From: [REDACTED]
Sent: 18 March 2019 11:27
To: [REDACTED]
Cc: [REDACTED]
Subject: RE: Questions for Breckland
Importance: High

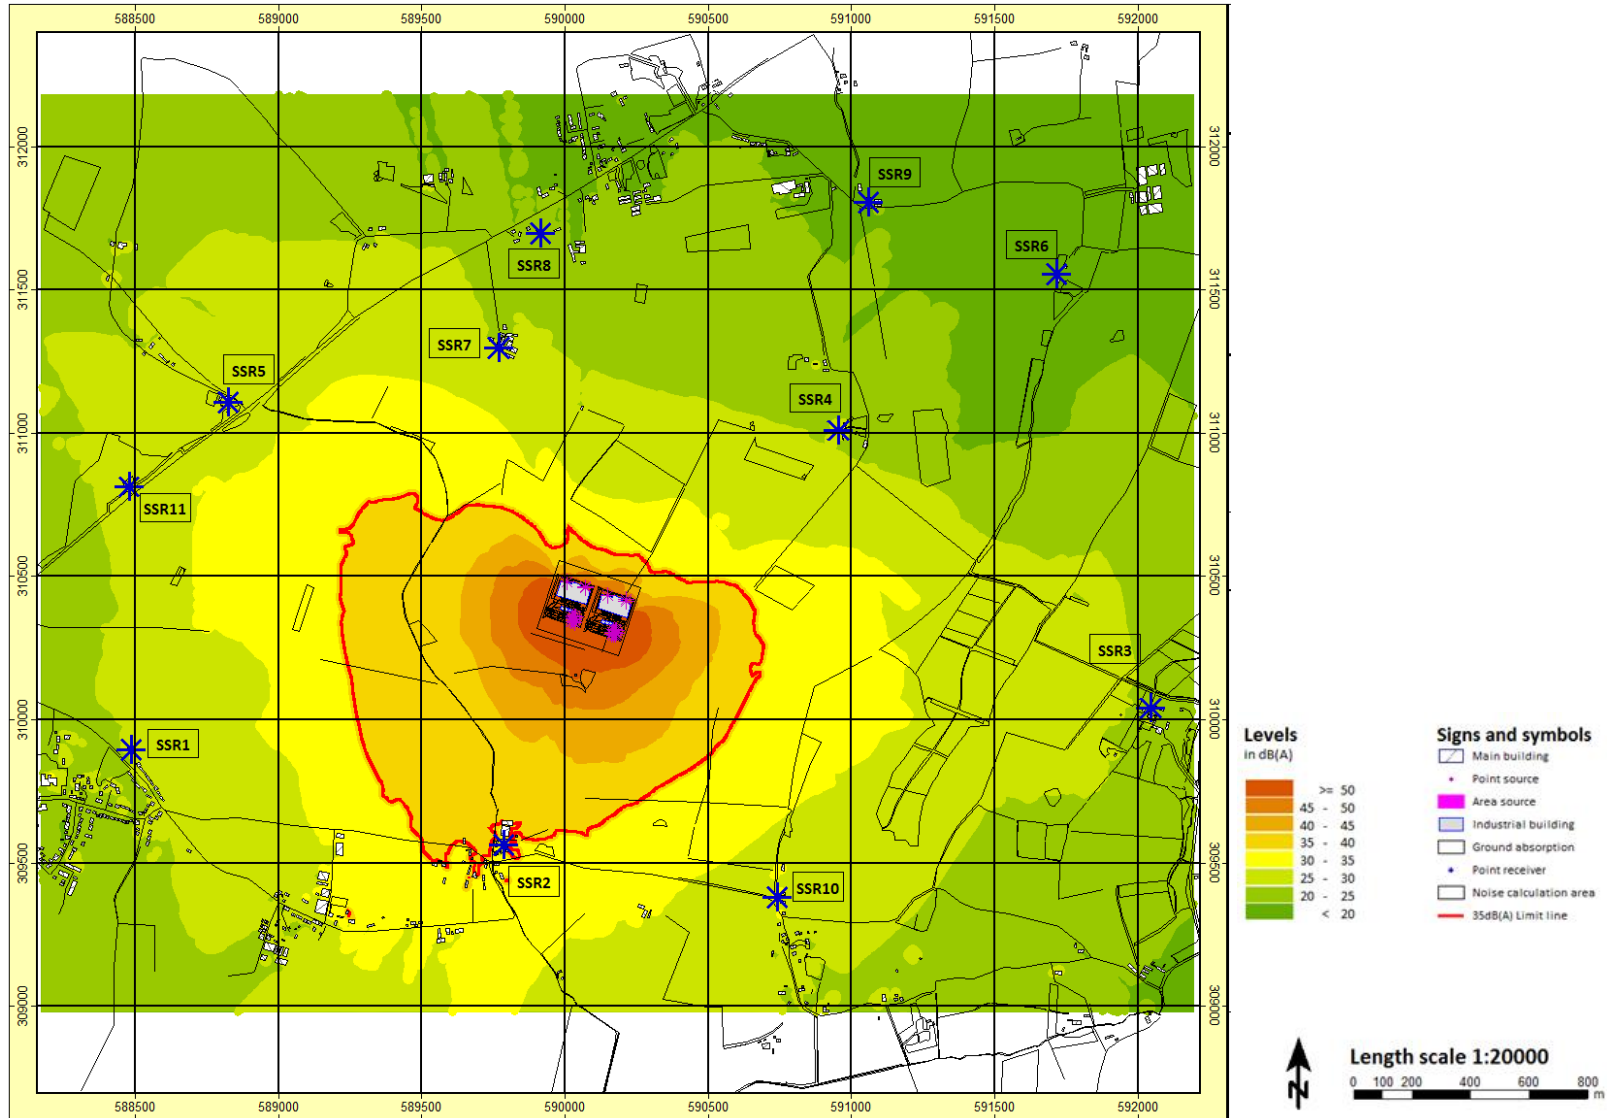
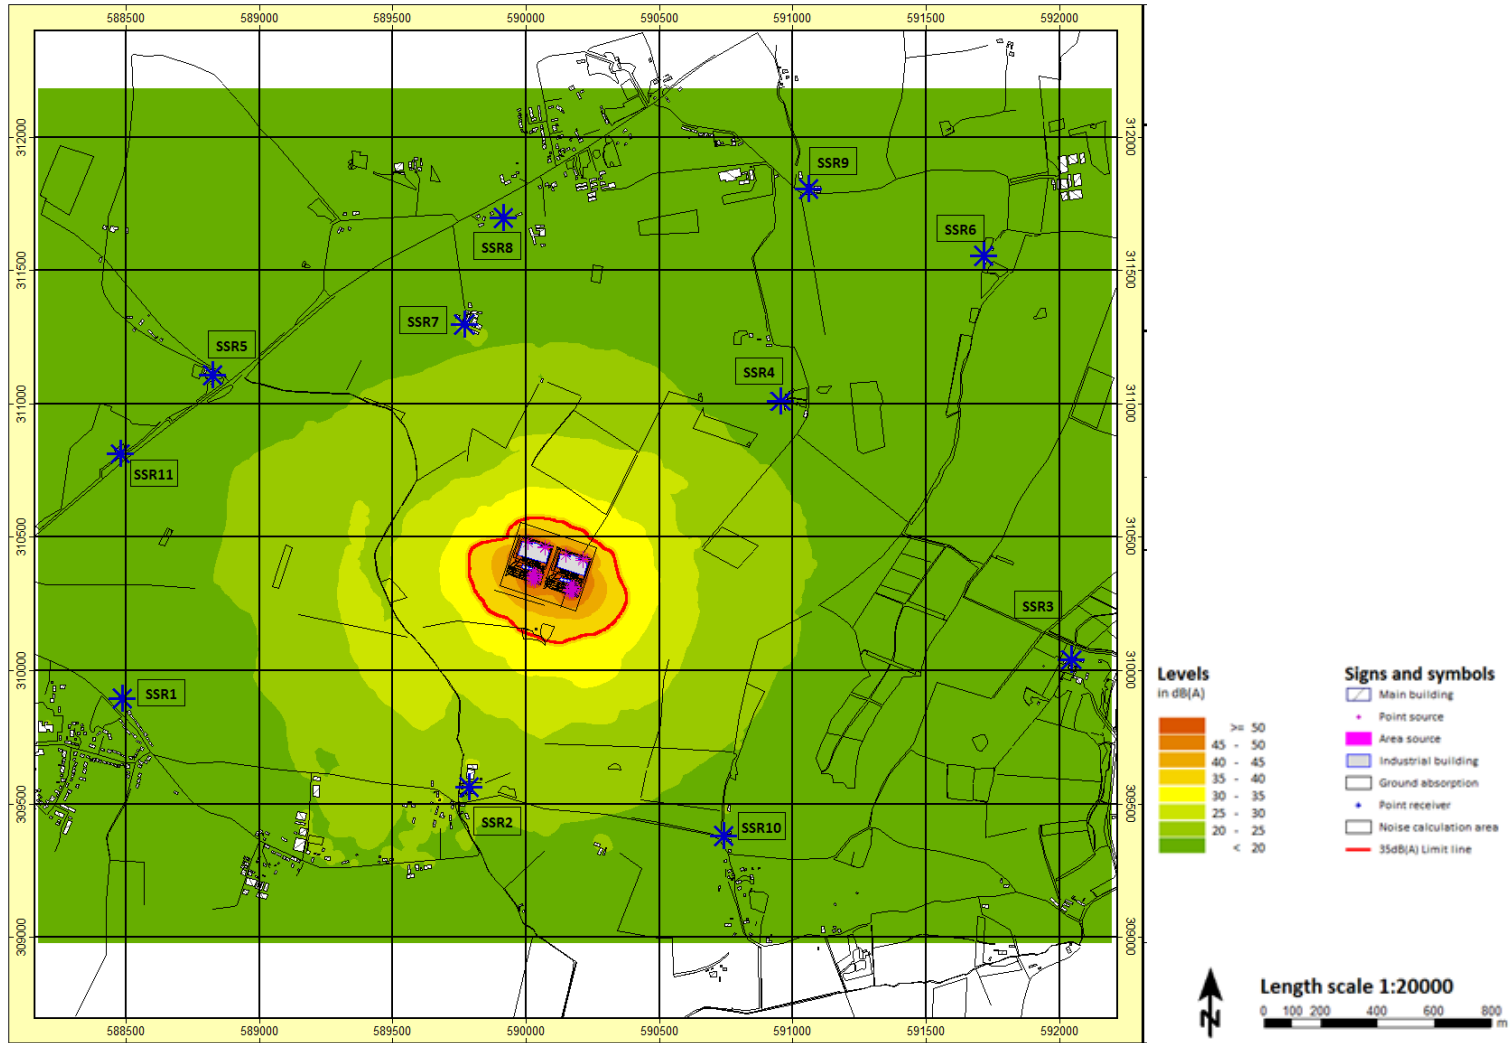
13.19 Breckland Council dDCO Requirement 27 (R27) sets out that the noise rating level for the operational phase in relation to Work No.8A must not exceed 35dB LAeq (minutes) and 32dB LAeq (15 minutes) in the 100Hz third octave band at any time at a free field location immediately adjacent to any noise sensitive location. Do you agree with the above limits?

13.21 Breckland Council The extension to the existing Necton National Grid substation has not been included as part of the noise modelling presented in ES chapter 25. Do you agree with this approach?

Yes, These limits were agreed during specific topic meetings with the applicant and align with the conditions set for the existing Dudgeon Substation. These limits are cumulative so will include any contribution from the existing substation. Any future projects will also have the same noise limits so as to avoid creeping noise threshold.

Extension to the existing Necton National Grid Substation is to be a separate application. The extension is not considered to contribute significantly to operational noise, however, it will be required to comply with noise conditions already set for the existing Substation, therefore I agree with this approach.
